CITY OF ALBUQUERQUE

**Re: Hollow Spirits Distillery
1324 1st ST NW
Request for Certificate of Occupancy
Transportation Development Final Inspection
Architect's Stamp dated 05-10-18 (J14D129)
Certification dated 11-06-18**

ACCESSIBILITY SIGNAGE

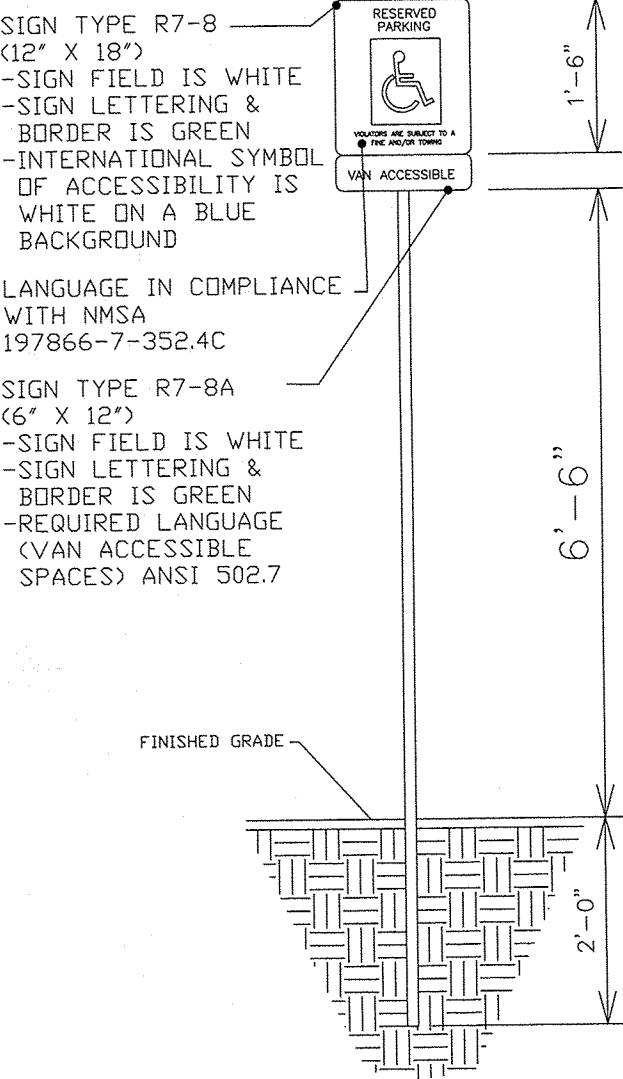
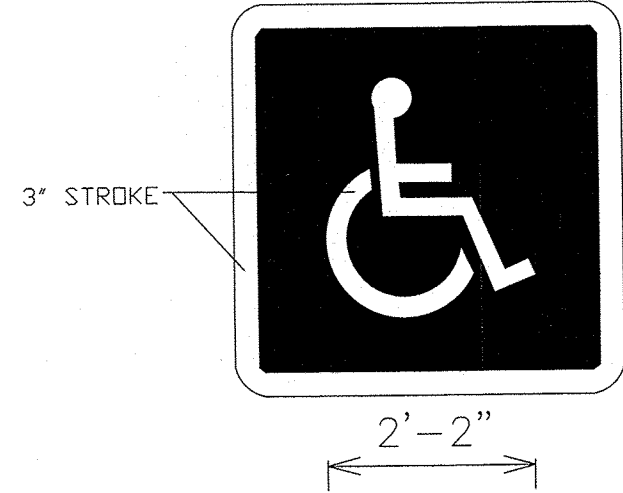
1. The ADA accessible parking sign must have the required language per 66-7-352.4C NMSA 1978 **"Violators Are Subject to a Fine and/or Towing."**
2. The ADA parking space next to the loading dock is missing a wheel stop.
